**Our ref:** NO/2021/113355/05-L01  
**Your ref:** 3/2021/0205  
**Date:** 26 November 2021

**ERECTION OF 36 RESIDENTIAL DWELLINGS, ALONG WITH LANDSCAPING AND ASSOCIATED SITE INFRASTRUCTURE.  
LAND AT NEDDY LANE, BILLINGTON, BB7 9LL**

We have reviewed the recent correspondence and plans submitted by Banners Gate, dated 5<sup>th</sup> November 2021 amongst previously submitted documents including:

Proposed Flood Plain Compensation Scale 1:250

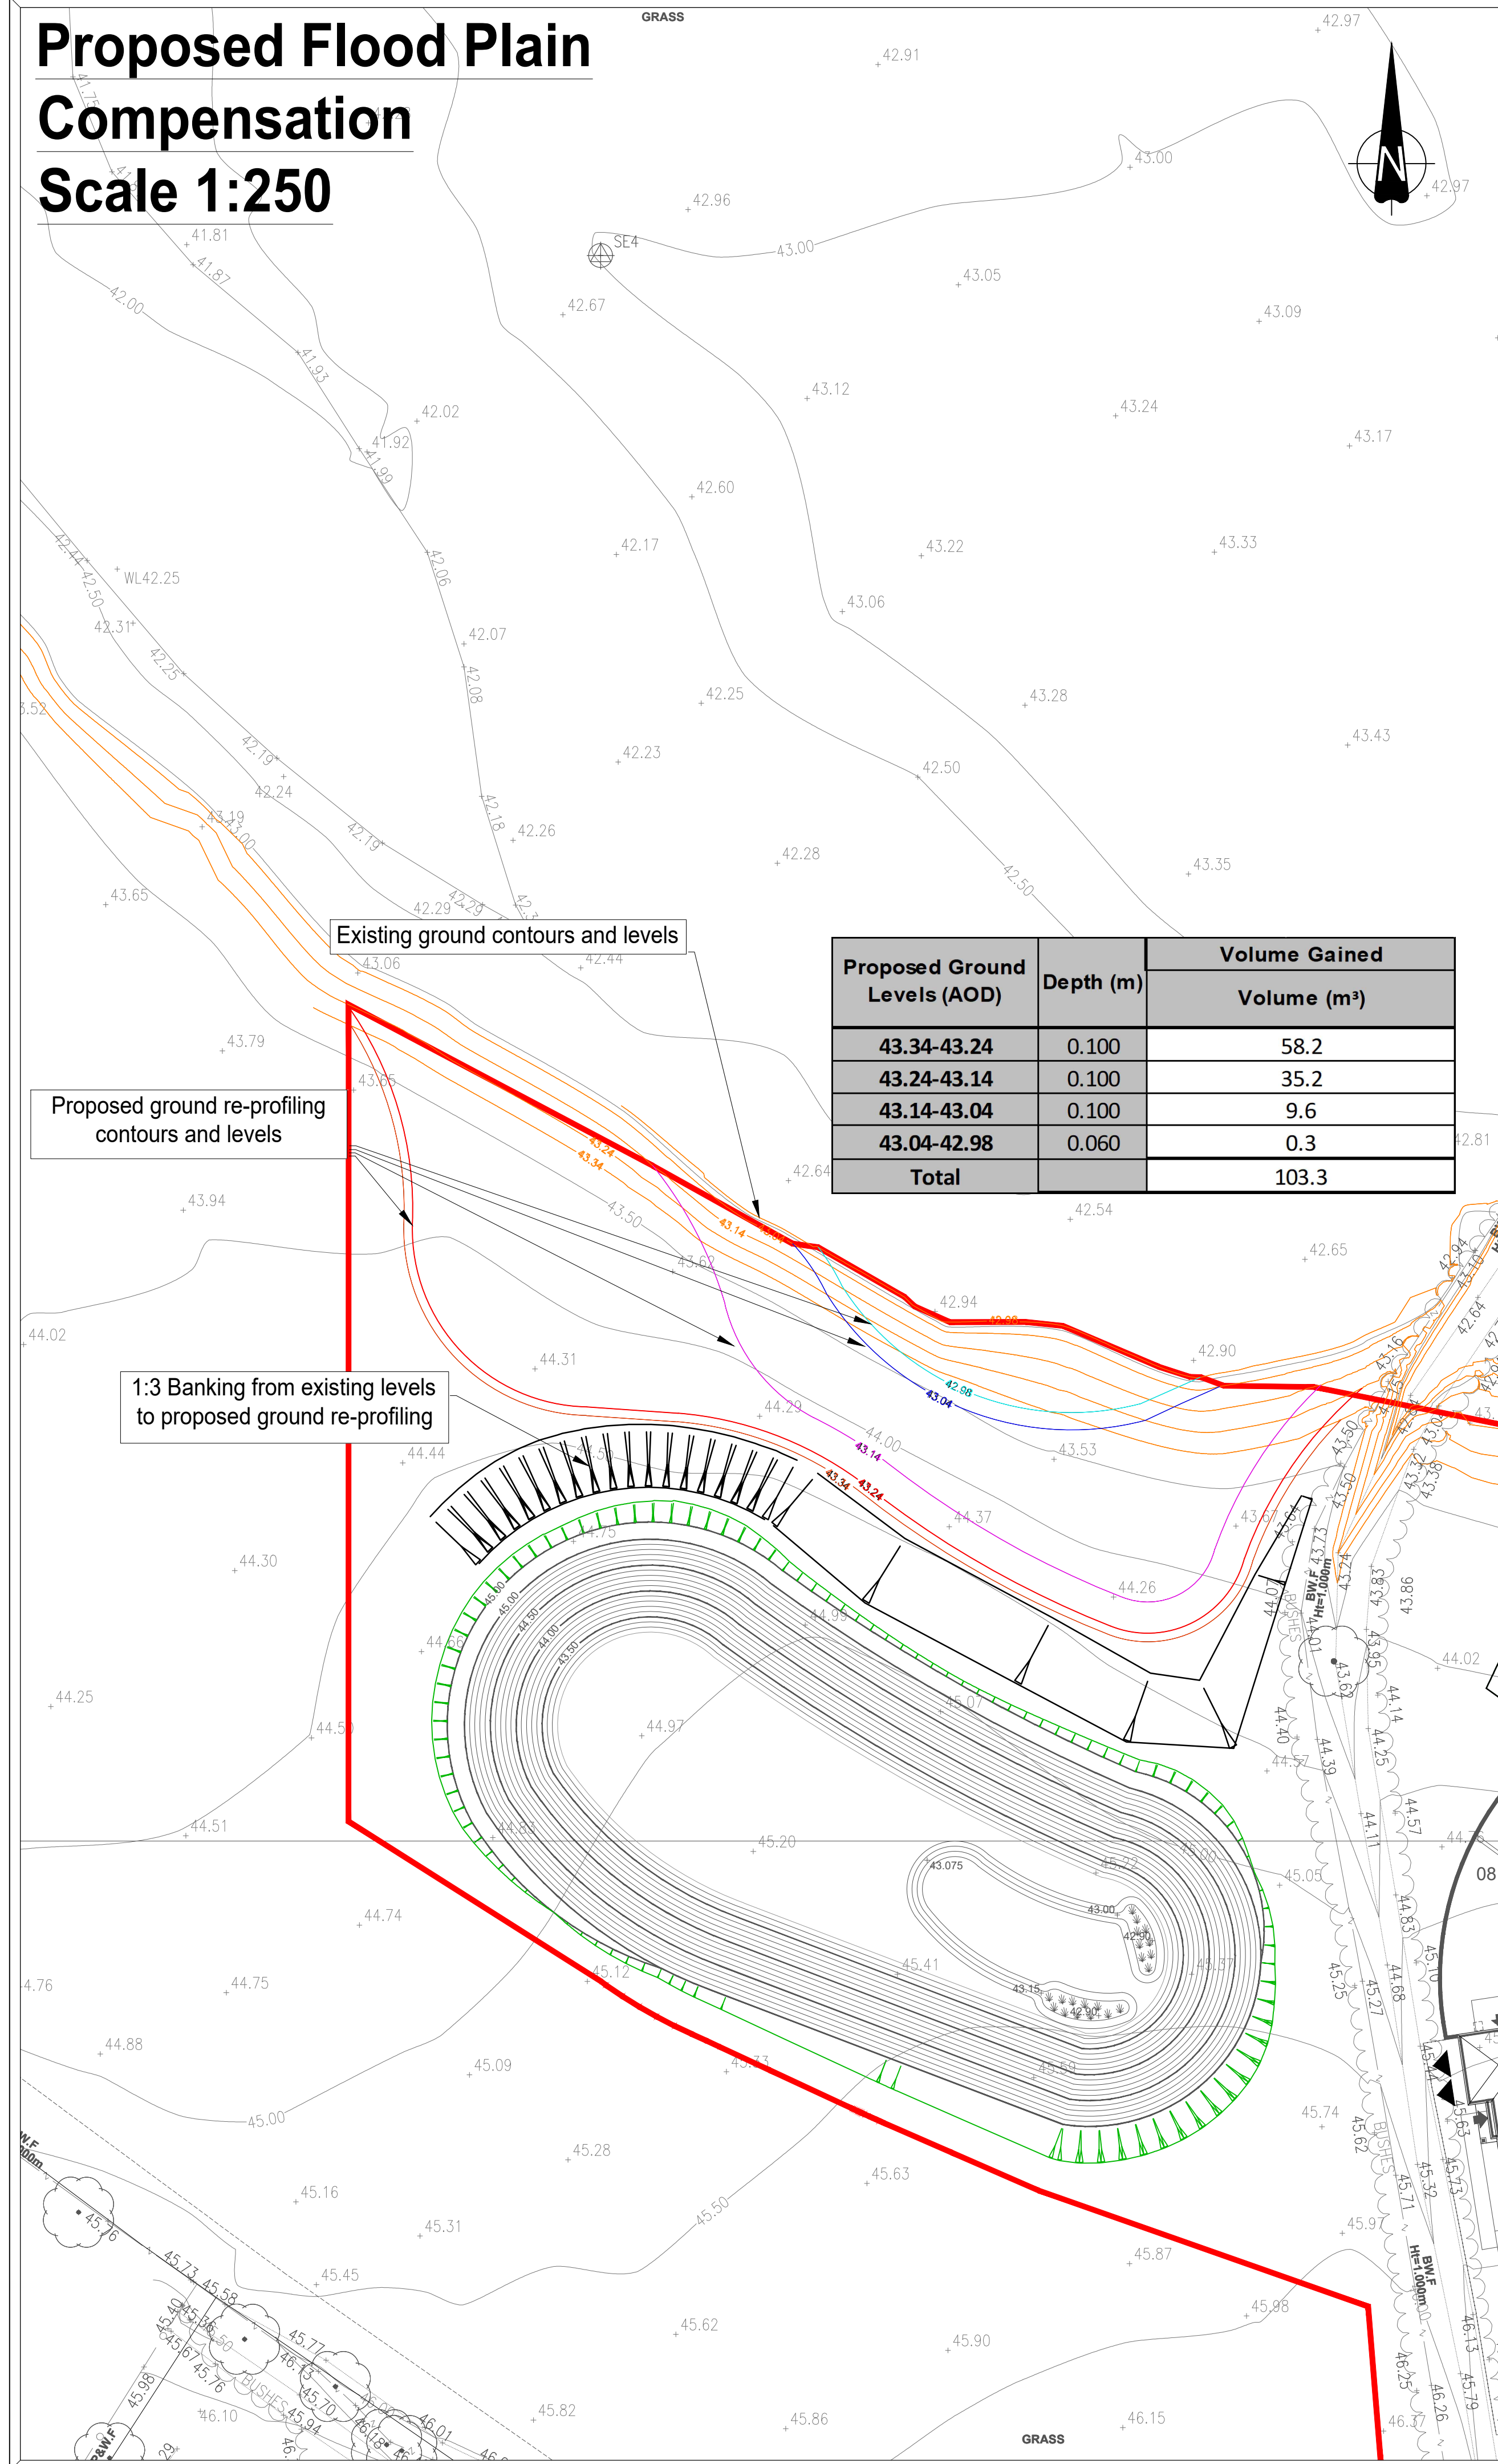
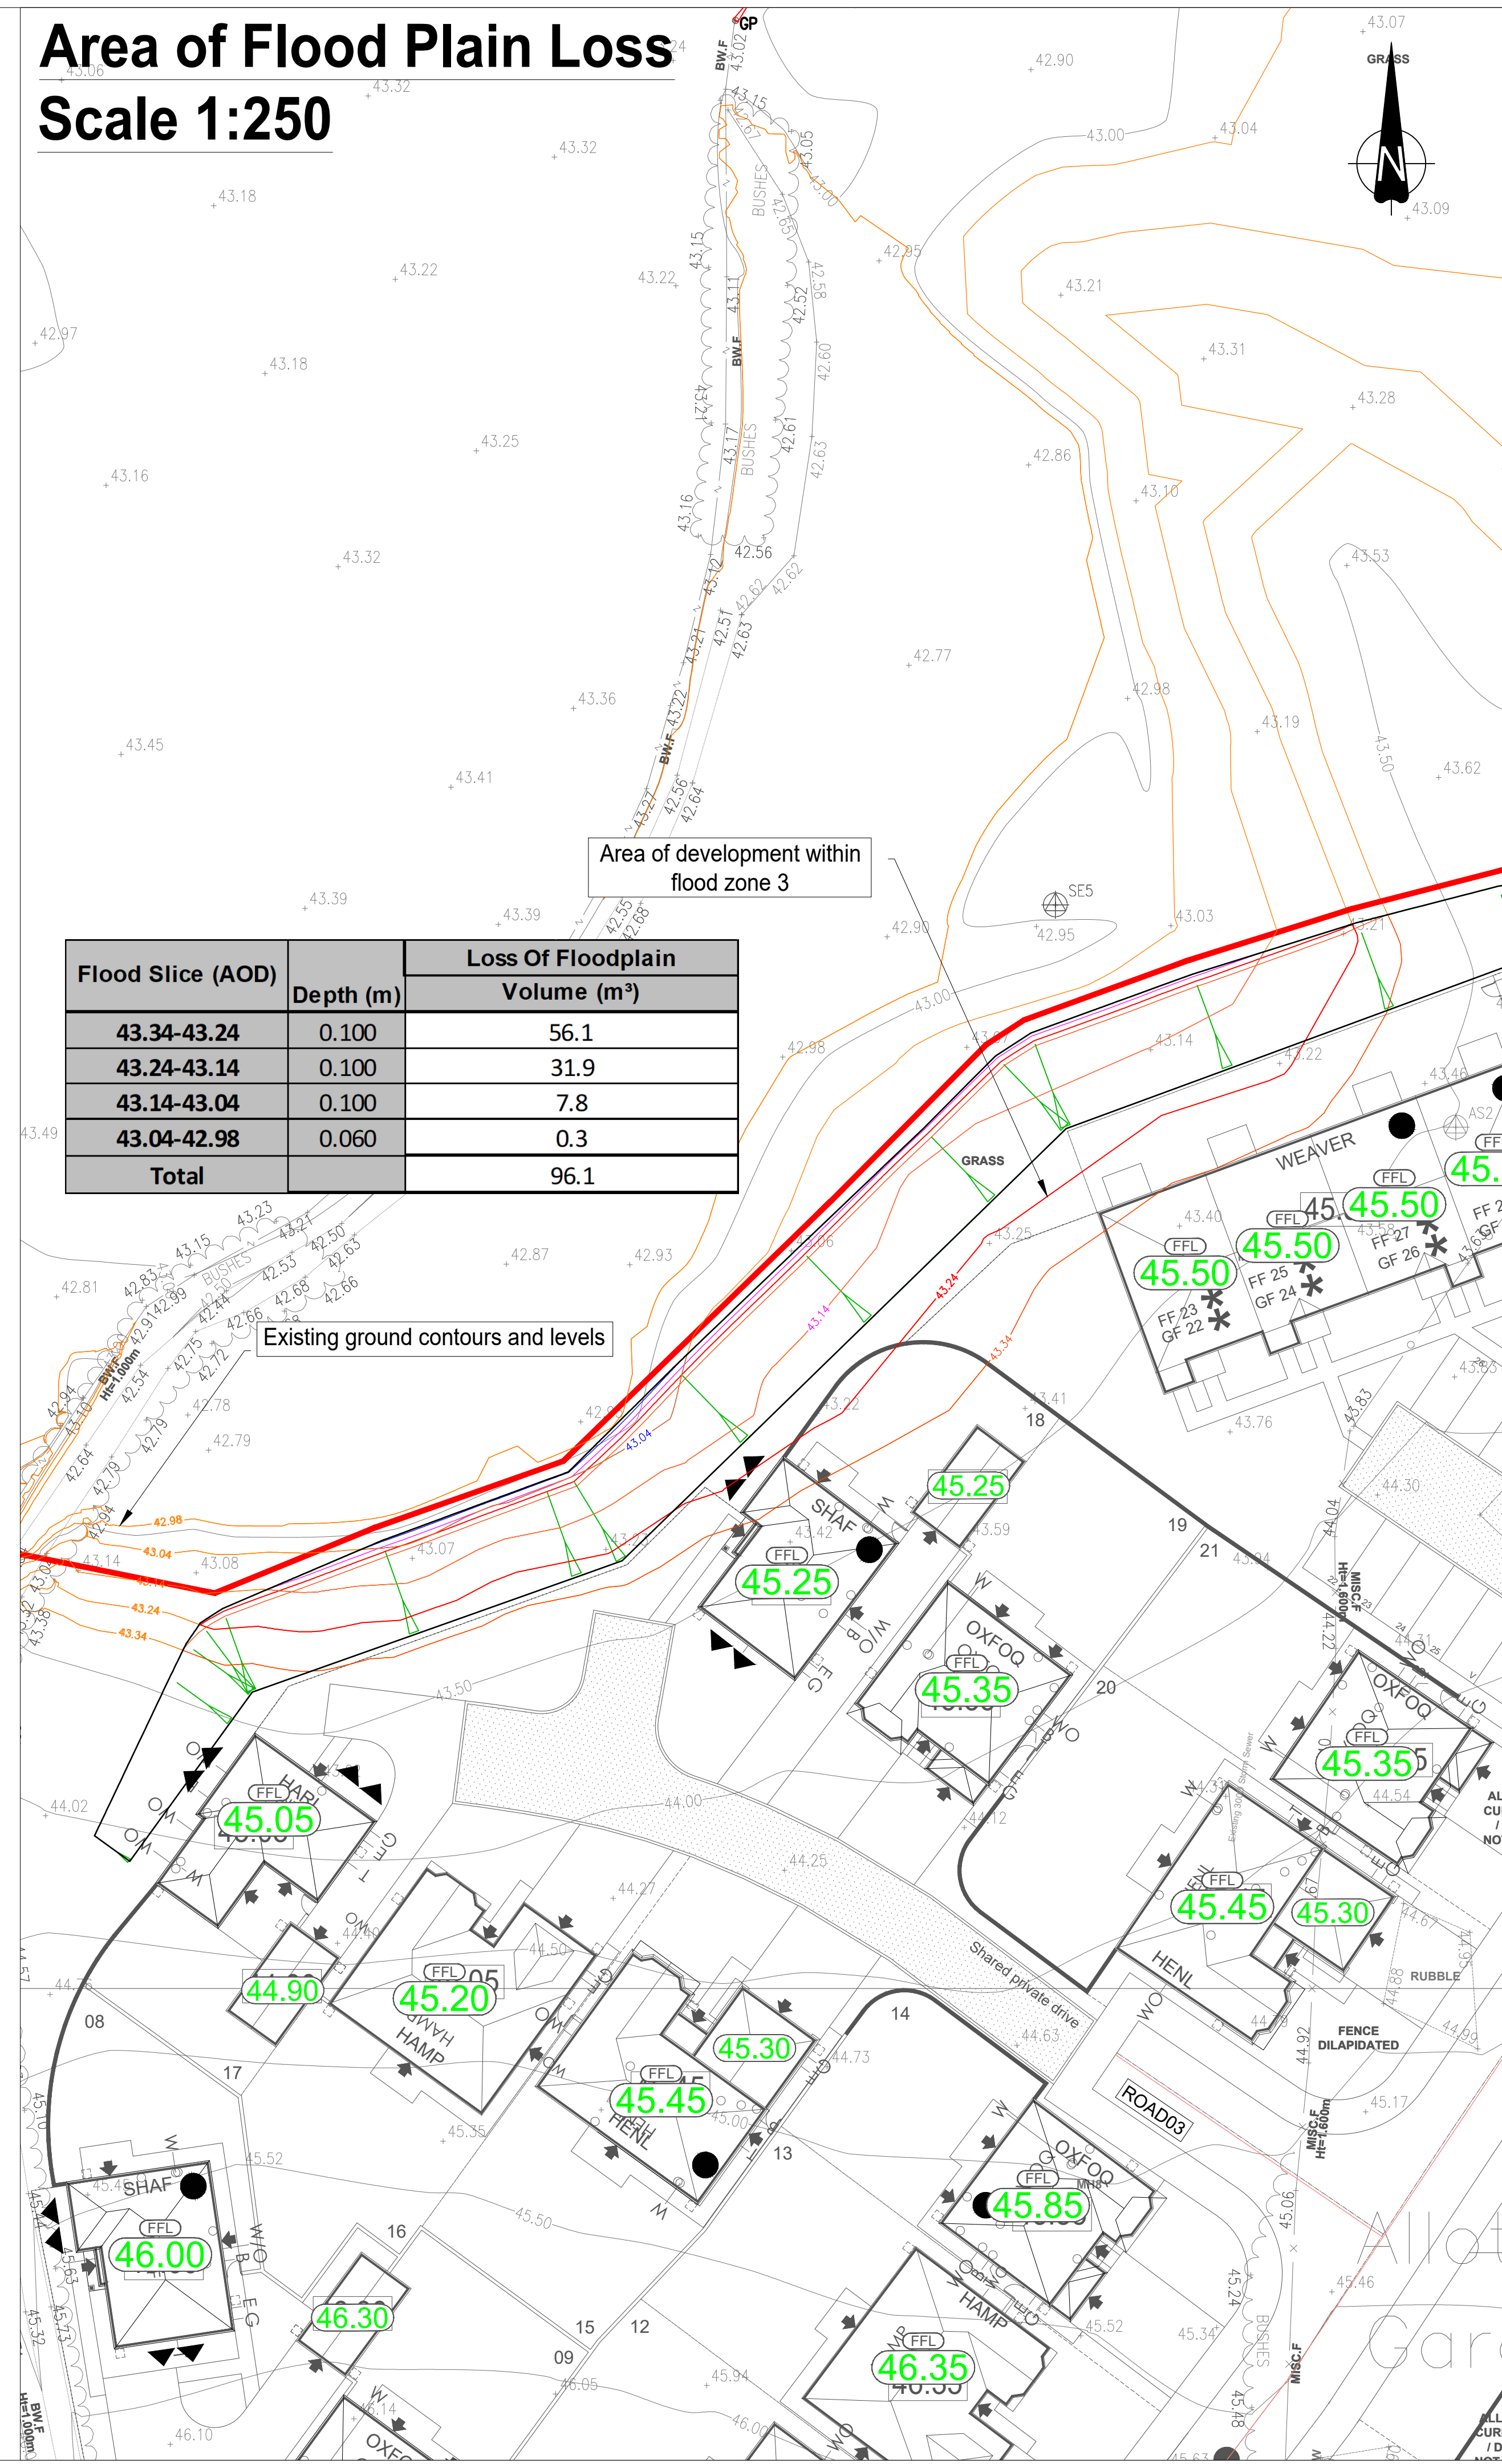
The applicant has since submitted details of the proposed compensatory storage scheme to demonstrate no increase in flood risk elsewhere. The scheme is mostly a level for level scheme however includes a connecting drainage channel between the

existing floodplain and the proposed storage area. The scheme is reliant on the channel design to ensure that flood waters enter and drain freely, safeguarding no loss in storage capacity. No detailed design of the scheme, including final engineering solutions for the proposed channel and storage area, has been submitted. We must also insist that excavation of the compensation area is complete before development/ infilling commences to ensure that floodplain capacity is maintained during construction of the development.

In addition, no maintenance details of the scheme have been provided. Continued maintenance and regulation of the proposed scheme is vital to ensuring floodplain storage is not reduced. The compensatory flood storage scheme is essential to ensure the development does not increase or exacerbate flood risk off site. The flood storage area must also be retained for the lifetime of the proposed development. Any future changes to or loss of this feature could increase flood risk off-site. Given the sensitivity of flooding in this location and the need to avoid the loss of or any changes to this flood storage feature, we must insist that it is secured as part of a planning obligation as part of any subsequent planning approval. In the absence of such an agreement, we cannot agree that the means to reduce the increased risk of flooding off-site as a result of the development will be in place for the lifetime of the proposed development and we may have to reinstate our objection to this scheme.

The development hereby permitted must not be commenced until such time as a scheme to provide appropriate compensatory storage on site has been submitted to, and approved in writing by, the local planning authority.

The scheme and plans submitted shall show the final engineering solution for the compensatory storage, providing detailed design to demonstrate how the scheme will function to ensure flood waters can enter the storage and be discharged freely after a flood. It must be demonstrated that there will be no loss in storage capacity for the lifetime of the development.

The scheme shall be fully implemented prior to any development on site and subsequently maintained, in accordance with the scheme's timing/phasing arrangements, or within any other period as may subsequently be agreed, in writing, by the local planning authority.
